DRB Application No.: 09DRB-70205 Project # 1007852
 Project Name: Mesa Park Addition
 Agent: Brasher & Lorenz Inc. Phone No.: _____

DRB Comments

RE: Tracts 1-B-1 / 1-B-7, Block 1, Mesa Park Addition

SUBJECT: TRACTS A-1-B, MESA PARK ADDITION
Preliminary and Final Plat
ZAP L-18

PLAT OF TRACT A-1-B, BLOCK 1 MESA PARK ADDITION

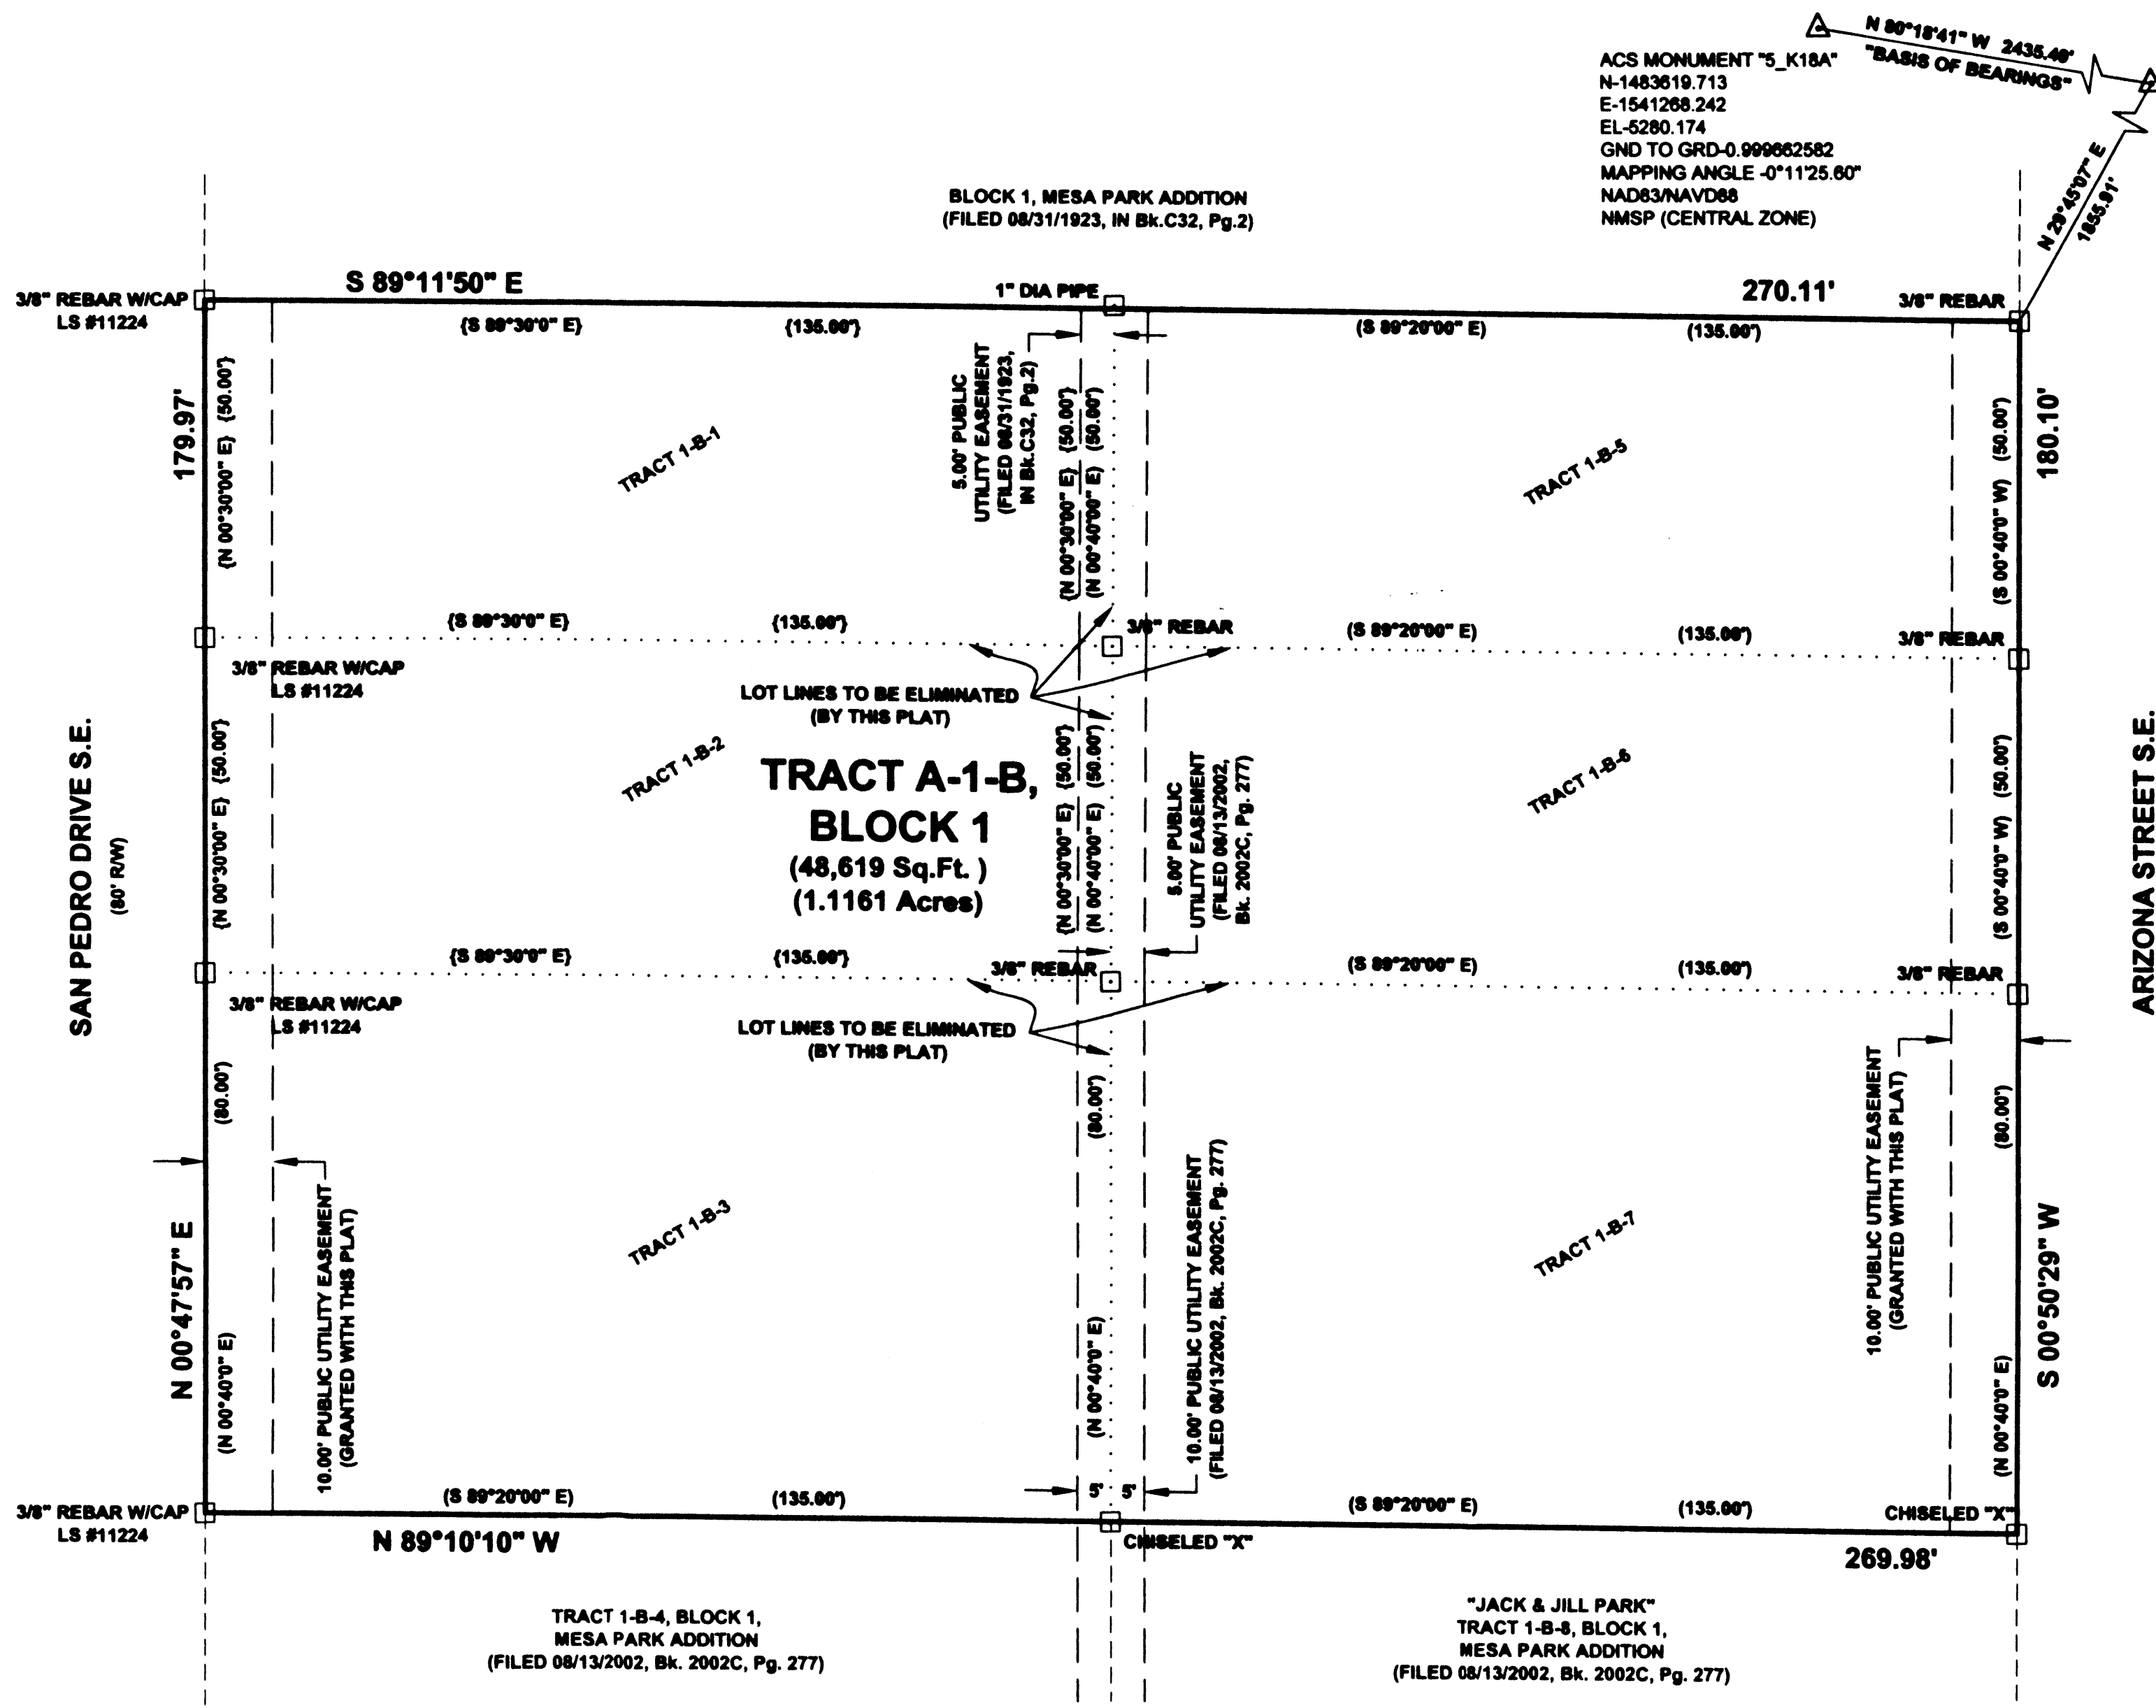
PLANNING (Last to sign): add solar Note

A Solar Note will be needed on the plat (consistent with Section 14-14-4-7 of the Subdivision Ordinance) which is specific to this type of request, i.e. use the words "THIS PLAT" (rather than the words "REQUESTED FINAL ACTION") at the beginning of the note, and do not use the words "OR SITE DEVELOPMENT PLAN FOR SUBDIVISION" at the end of the note.
